**KIRKLEES METROPOLITAN COUNCIL  
INVESTMENT & REGENERATION SERVICE**

**DELEGATED DECISION TO DETERMINE PLANNING APPLICATIONS**

Reference No:	<b>2024/62/90342/W</b>
Site Address:	8, Boulder Gate, Marsden, Huddersfield, HD7 6LJ
Description:	Erection of single storey rear extension with roof terrace above, external alterations and extension of existing garage
Recommending Officer:	Lucy Taylor

## **Officer Report.**

1:50 scale

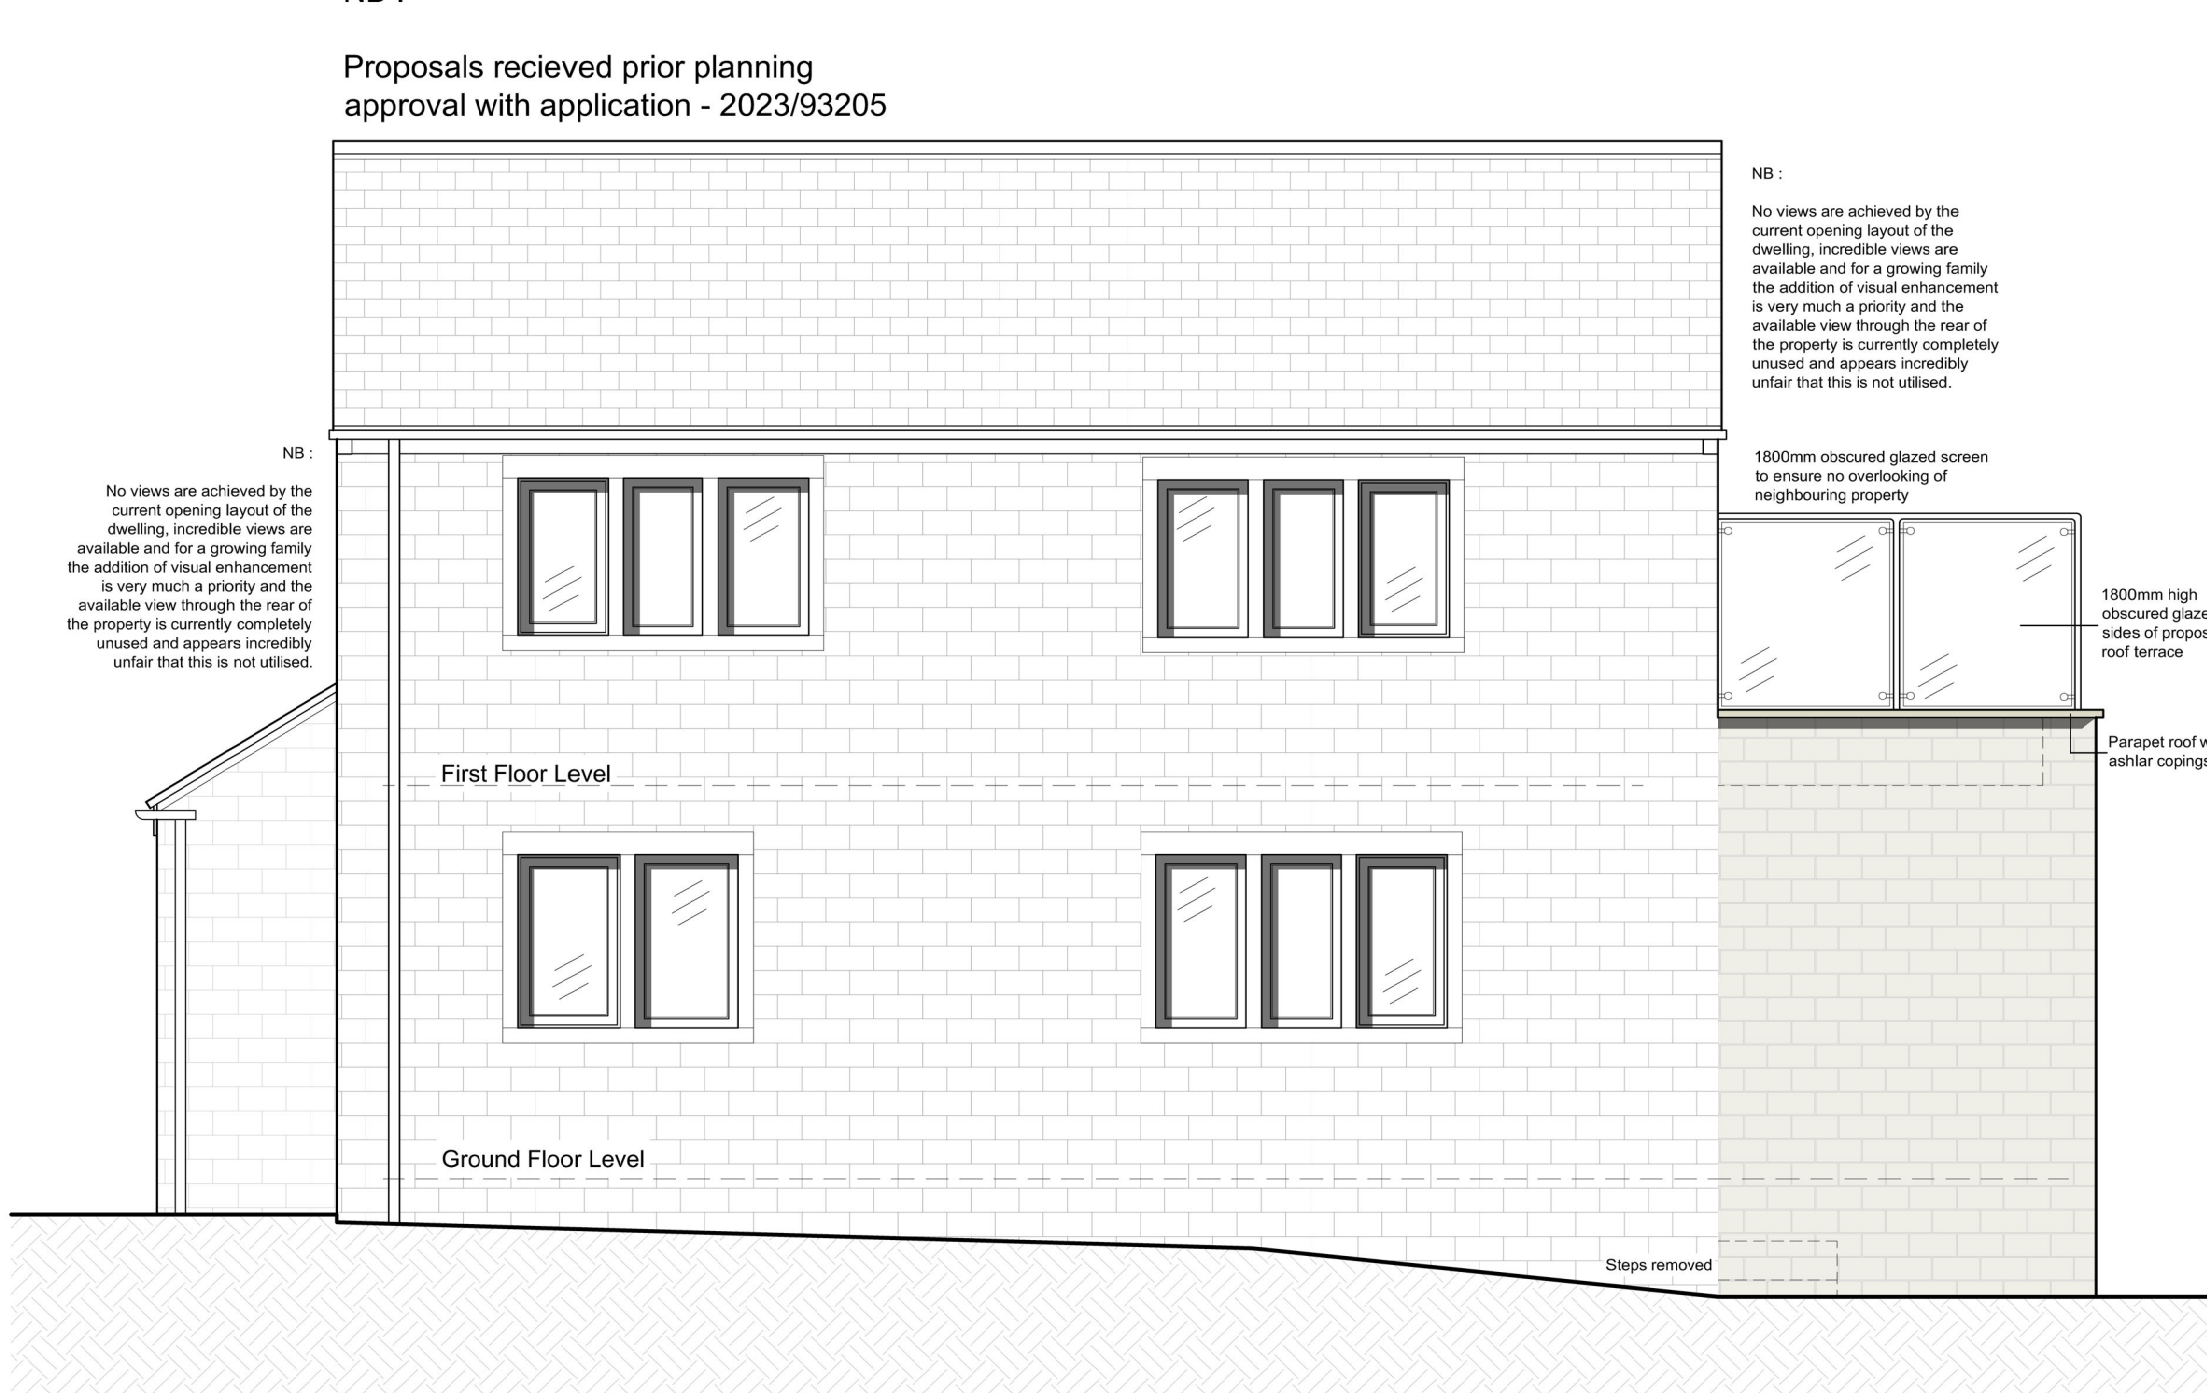
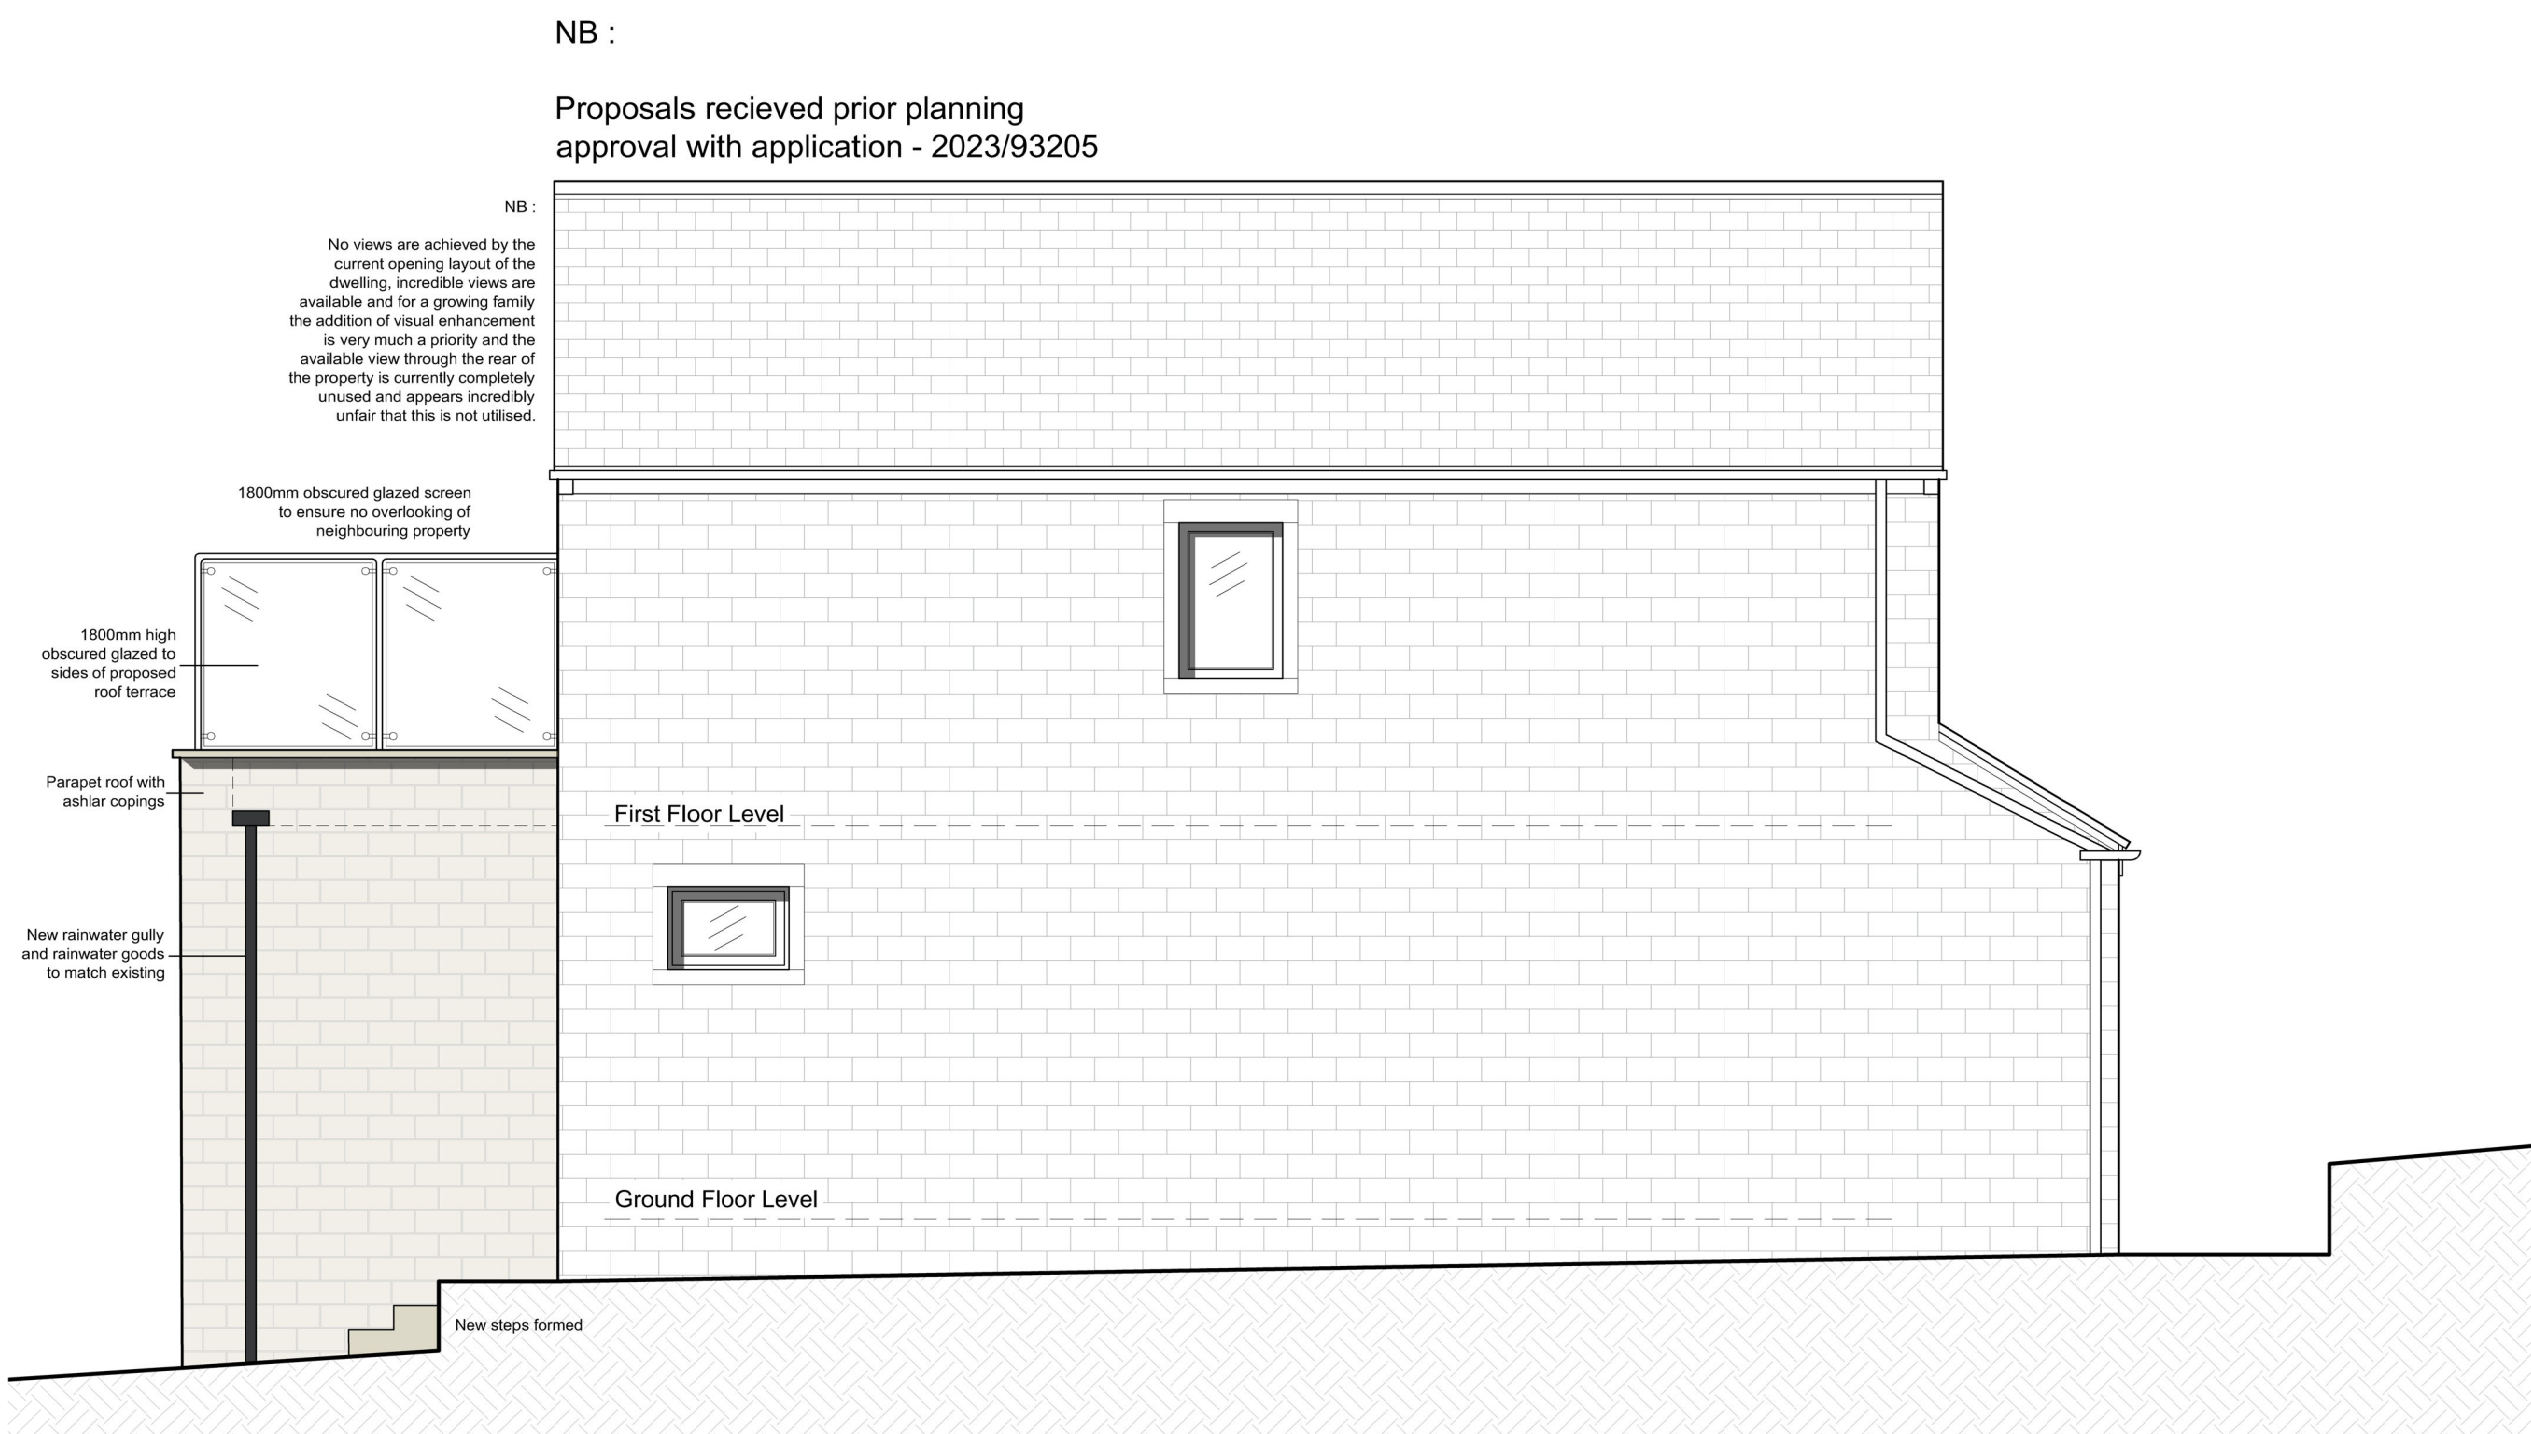
The proposed extension would have a projection of 2.5 metres, with a width of 3.4 metres and a height of 3.85 metres. The extension would be faced in coursed stone.

The roof terrace would be above the flat roof of the extension, with 1.1 metres high glazed balustrade to the front elevation and 1.8 metres high privacy screen to both side elevations. New double glazed patio doors are to be installed to the host property to provide access to roof terrace.

The host property of 8 Boulder Gate is detached, and the extension would have a projection of 2.5 metres, with a height of 3.85 metres. These dimensions are considered to result in an extension which would not cover more than half the total area around the original house and would be considered subservient from a visual amenity perspective. In addition, the extension would retain a minimum separation distance from any boundaries of curtilage of approximately 1.2 metres.

The proposed roof terrace would have 1.8-metre-high privacy screens to both its side elevations. The incorporation of these privacy screens is considered to be sufficient to mitigate any undue impacts of overlooking to either Cartref or No. 6 Boulder Gate and a condition to ensure they are in place before the terrace is brought into use would be included upon any grant of approval. The proposed obscure glazing would reduce the massing of the roof terrace above the ground floor extension. It is noted in objections and from observations on site that the 'open' rear boundary of the roof terrace would look towards an element of the front garden area of Cartref. However, this would be towards the driveway and then onwards to Gate Head itself. It is concluded that this outlook would not result in an undue loss of privacy or overbearing impact.

4. The roof terrace shall not be brought into use until a 1.8-metre obscure glazed privacy screen has been placed on both side elevations of the roof terrace, as shown on dwg no. 02223/PP/02/R02. The two 1.8-metre obscure glazed privacy screens shall be retained thereafter.
